Planning Application No: 3/2024/0566

Proposal: Proposed conversion of garage, replacement of garage door with a window and insertion of window facing no. 10, enlargement of existing side extension including replacement of flat roof with a pitched roof and insertion of a window in the gable end facing No. 6.

Location: 8 Carter Fold Mellor BB2 7ER

Proposed Site Plan  
Scale (1:500)

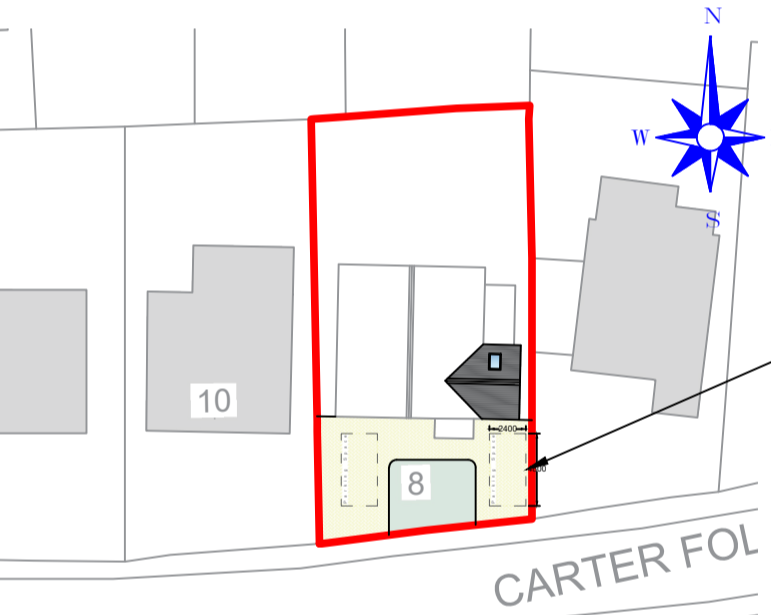
No parking plan has been provided. A parking plan must be submitted to show that 2 parking spaces can be provided within the curtilage of the property. Parking standards requirement is for 3 bedroom residential dwellings to provide two parking spaces within the curtilage of their property. The 2 parking spaces required must be 2.4m x 4.8m in size each.

Proposed Site Plan
Scale (1:500)

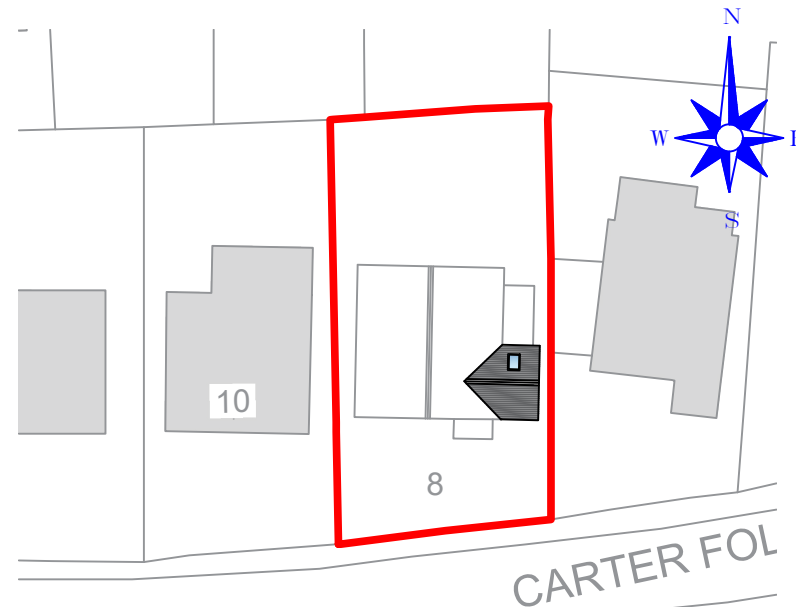
There is no change in the number of bedrooms, existing 3 and proposed 3 with this proposal. The proposal creates the loss of a garage and therefore a loss of 1 parking space.

Parking on a turning head is not acceptable for highway safety reason.

The proposed development should not be brought into use unless and until the parking area has been constructed, laid out and surfaced in bound porous materials. The parking area shall thereafter always remain available for the parking of domestic
